From: Simon Davis
Sent: 28 August 2020 11:40
To: Patrick Barry [REDACTED]
Cc: Nick Culhane [REDACTED]
Subject: RE: BN/39/20/PL - Members Briefing

From: Simon Davis <Simon.Davis@arun.gov.uk>
Date: Friday, 21 August 2020 at 15:17
To: Patrick Barry [REDACTED]
Subject: BN/39/20/PL - Members Briefing

STREET ELEVATIONS

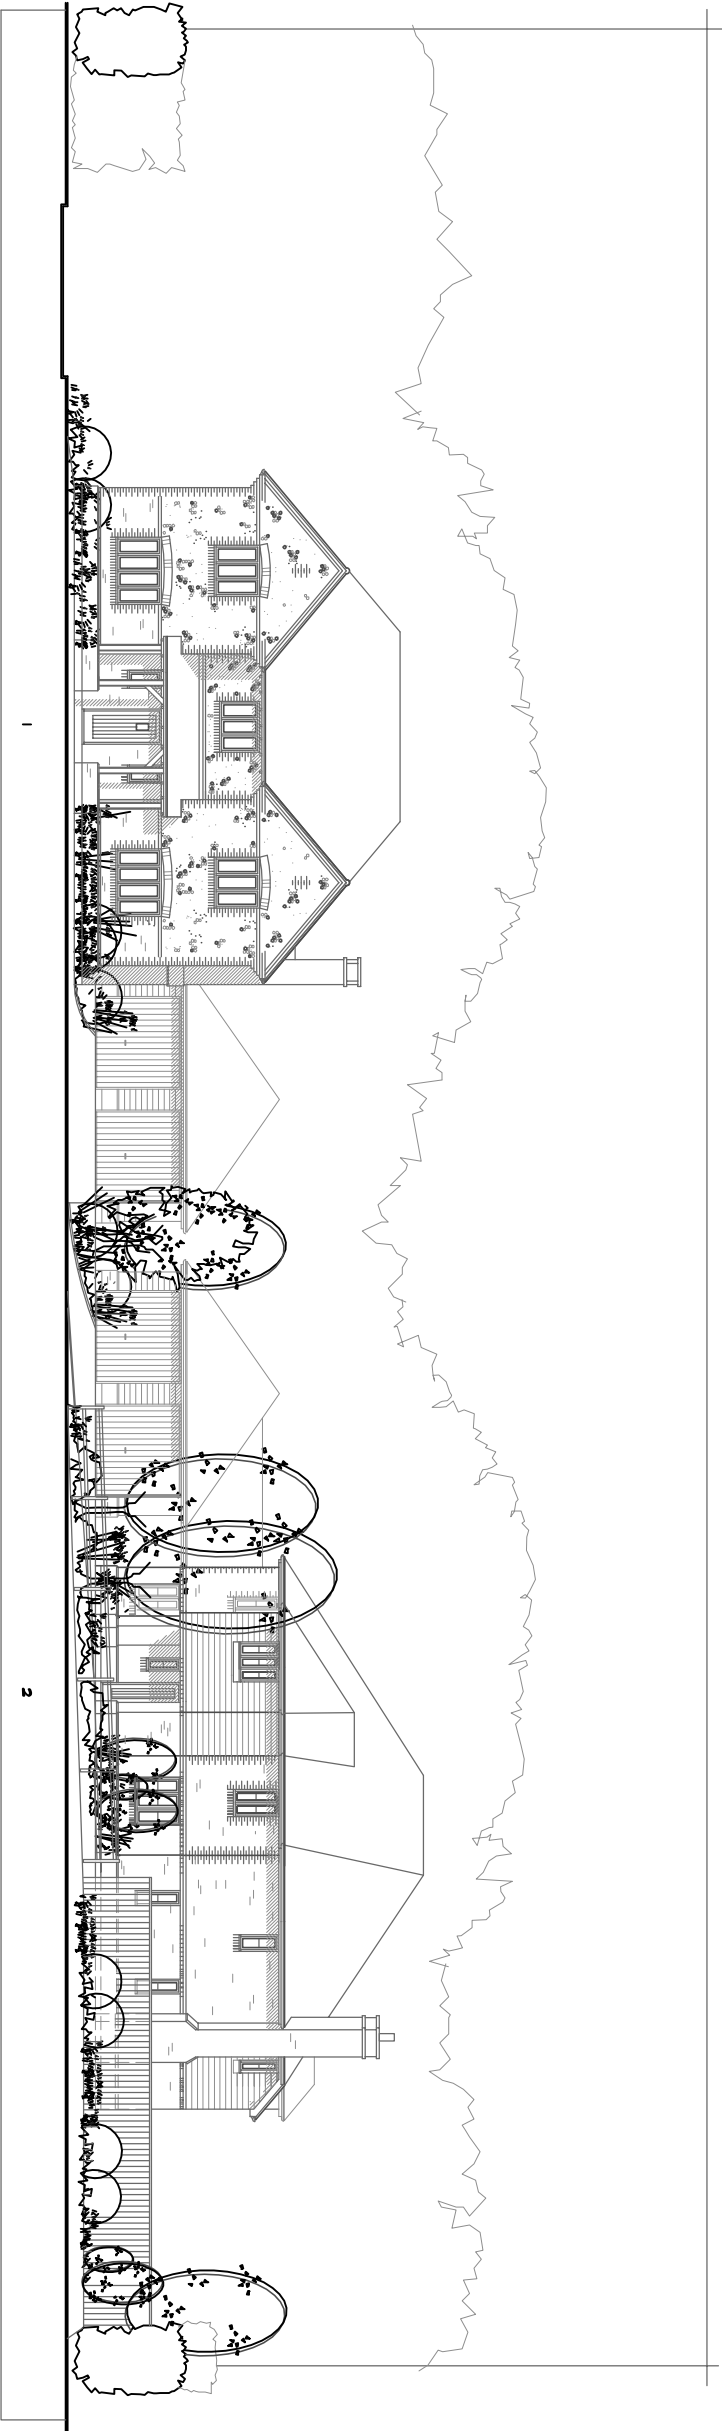
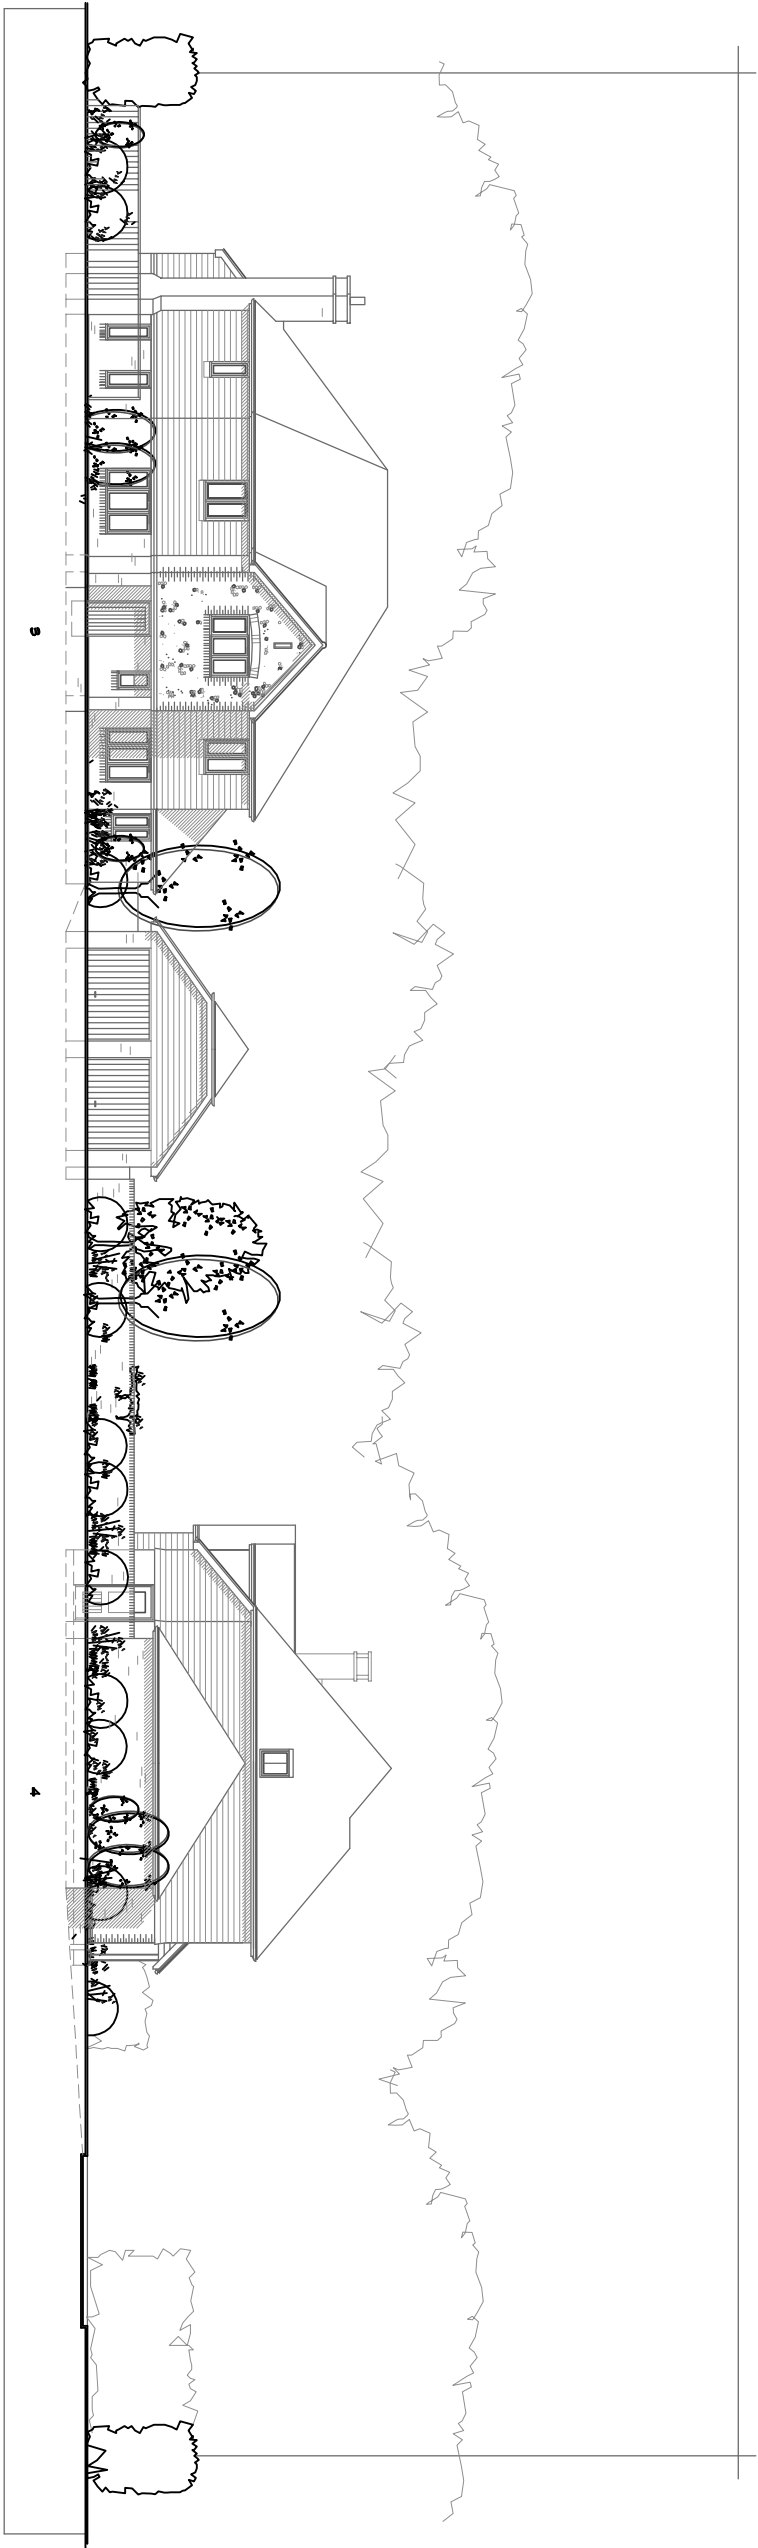
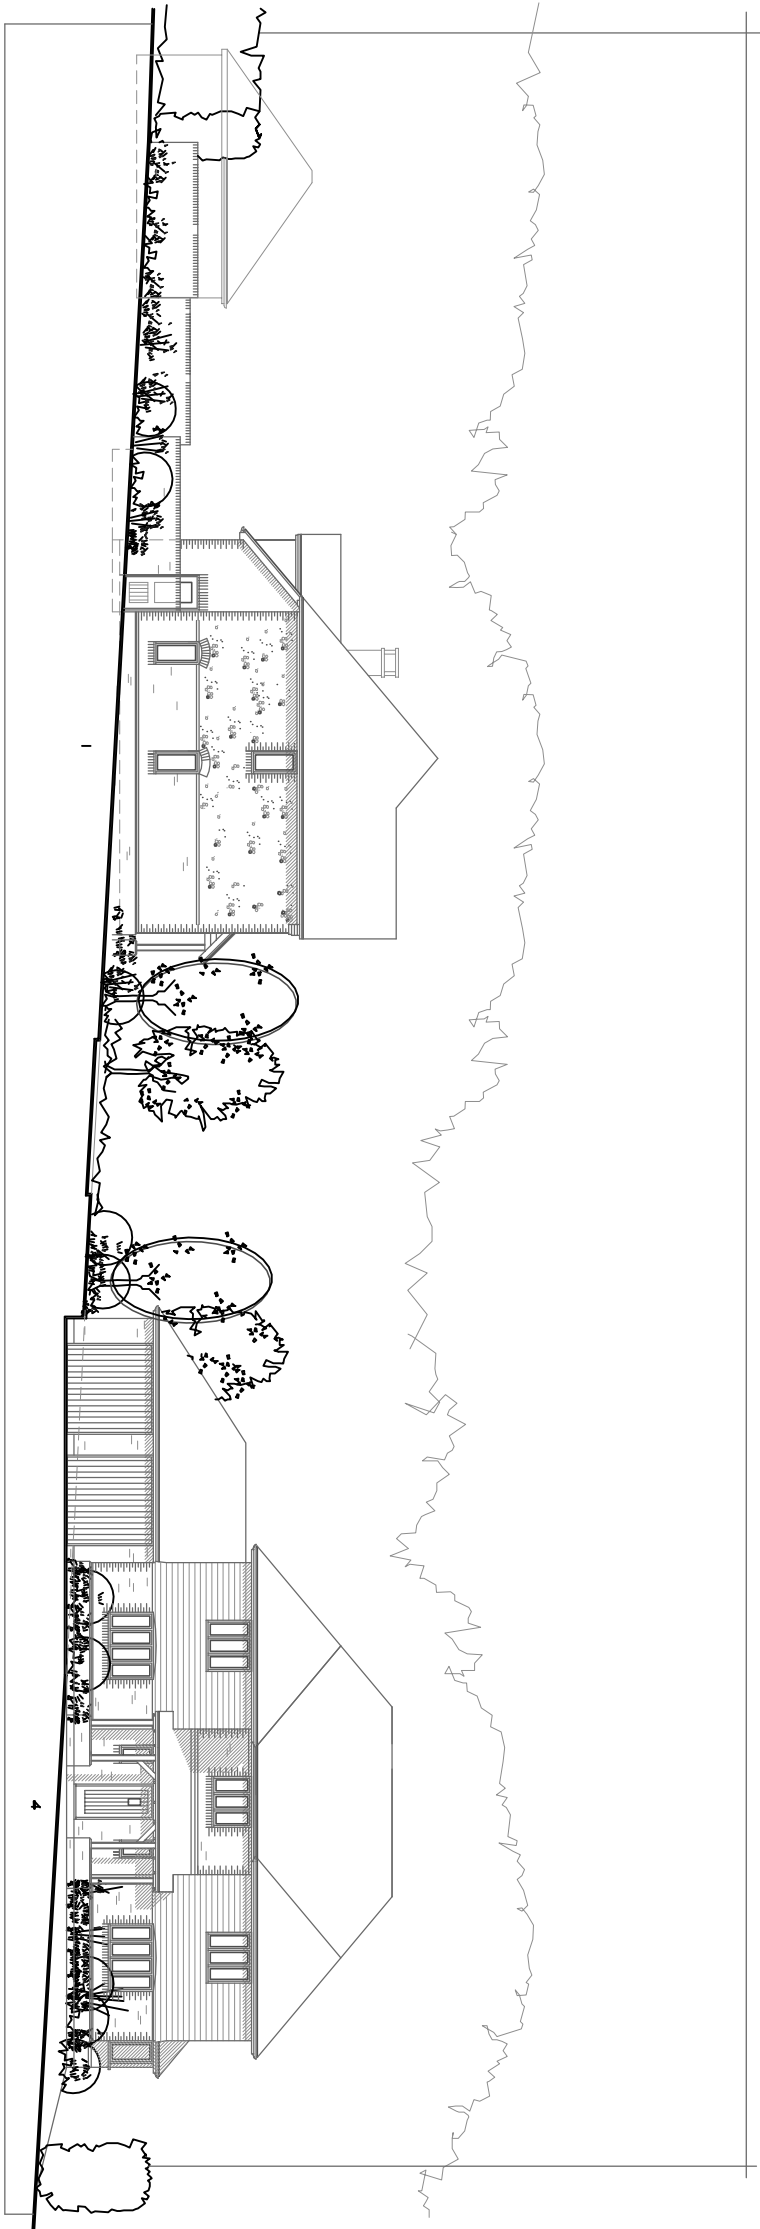
They weren't sure of the levels change across the site and how the houses are to be constructed on the slope. We will show the topo on the Ctte presentation and I have worked out the average levels change from top to bottom so that is covered. Re how the houses are to be constructed, this is indicated only by one of the streetscenes. Would I be right in telling members at Ctte that the houses are to be achieved by combination of cutting into existing ground, use of retaining walls and raised ground floor levels? A member also asked whether the foundations would be rafted?

Figure 7: Swept Path Assessment

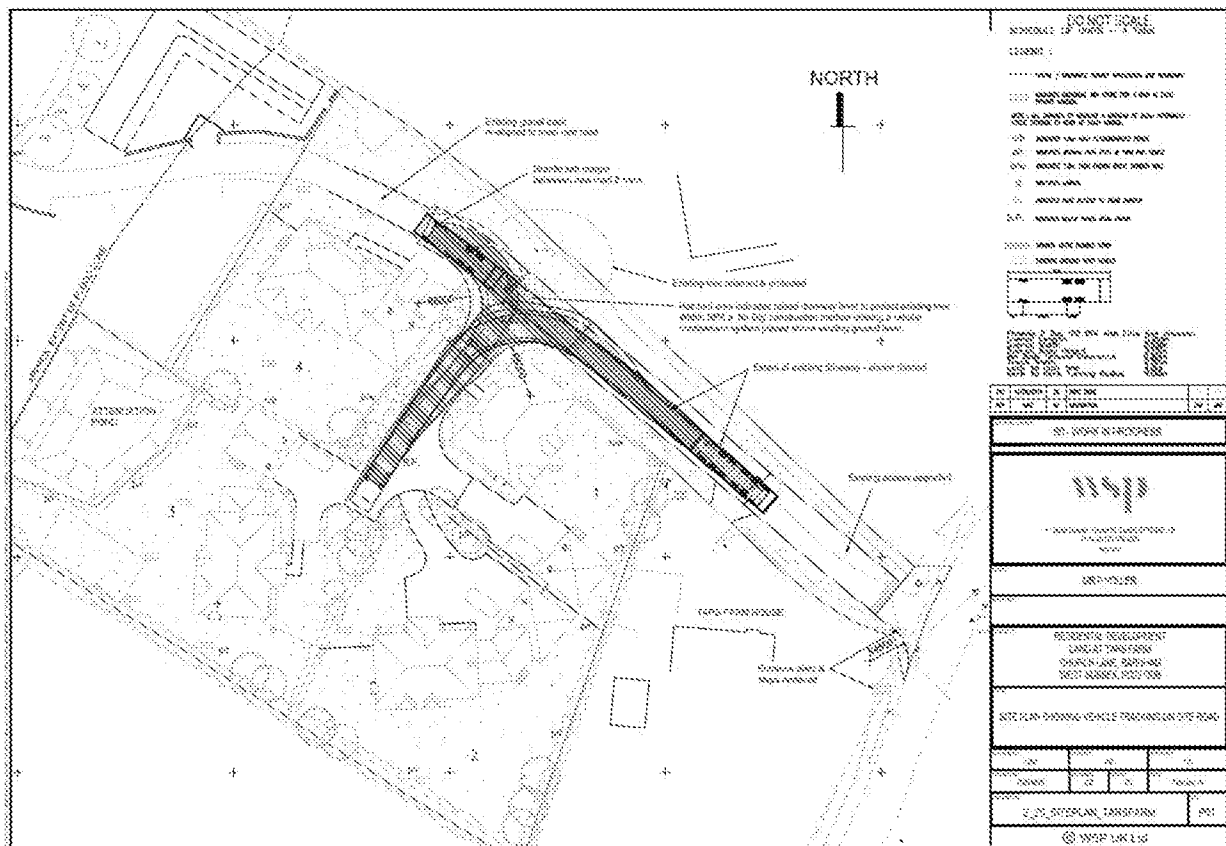
The consideration of building regulations pertaining to emergency access and refuse collection needs deliberation at the planning stage. A consideration to wherever or not a development is subject to such consideration is made by its location from the nearest publicly maintained highway (minimum of 50 metres). For this proposal the nearest publicly maintainable highway Church Lane is located 112 metres from the furthest building point.

There is no indication of any waste storage or collection points on the proposed site plan.

The LHA advises the LPA to consult with the waste collection authority to determine the suitability of any waste collection point.

As described in Paragraph 6.8.9 of Manual for Streets (MfS), the carry distance must not exceed 30 metres.

Further to our conversation yesterday, I have reviewed the TS and there is a refuse tracking plan – can you clarify what the issue was so that I can review this with Nick (copied here).
